Consultation Response from KC, Highways Development Management
2021/92279 Upper Langley Farm Former, Langley Lane, Clayton West, Huddersfield, HD8 9HY
Siting of static caravan for agricultural worker for temporary 3 year period and livestock building
Date Responded: 28/09/21
Responding Officer: J Turner
Responding Ref: K17-39/25

This application seeks approval for the siting of static caravan for an agricultural worker for a temporary 3-year period and livestock building at Langley Lane, Clayton West.

Date:	Scale:	Size:	Drawn:	Checked:
May '21	1:1250	A1	MS	ADP
Project No:	Dwg No:	Rev:	Status:	
3020	005		Planning

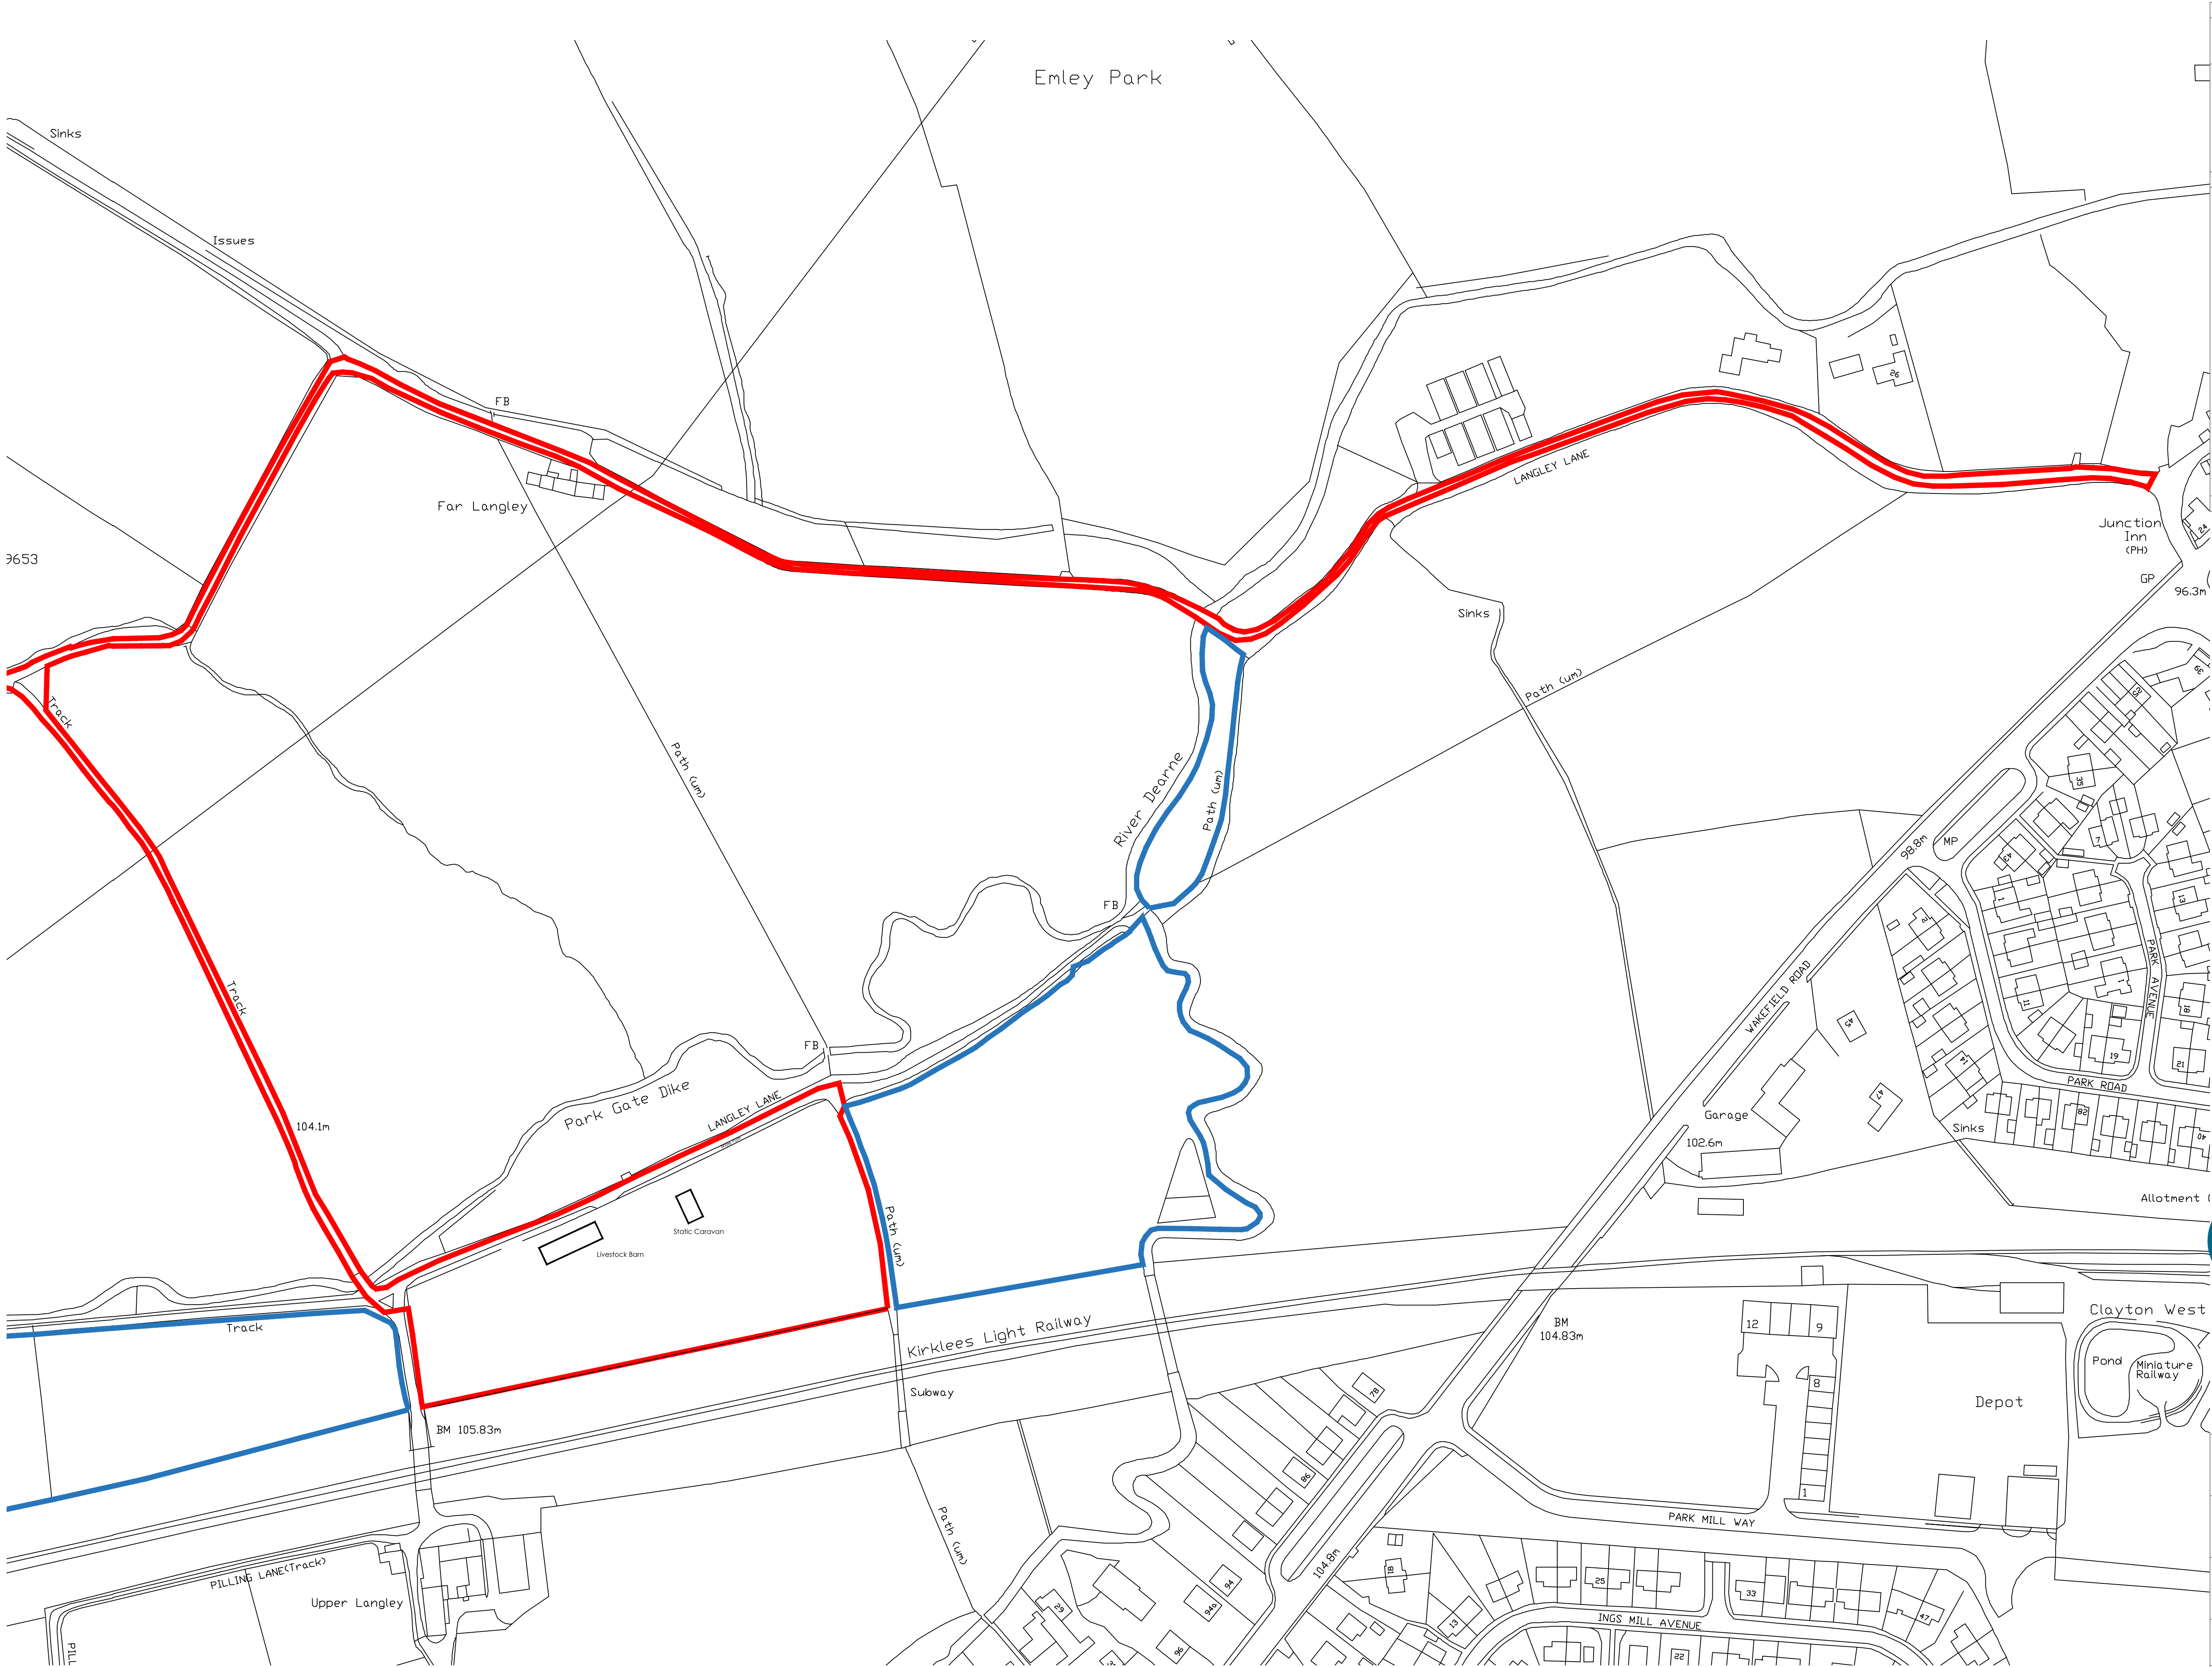
Highways DM would ask for details to be resubmitted to ensure the access issues have been addressed as per the 2018 application. Concerns include the suitability of the access, particularly the treatments required to form a suitable access from Langley to the site Lane (and improvements to the bridge thereon), the intensification of use of Langley Lane itself, and the proposal to have refuse collected such a distance from the site.
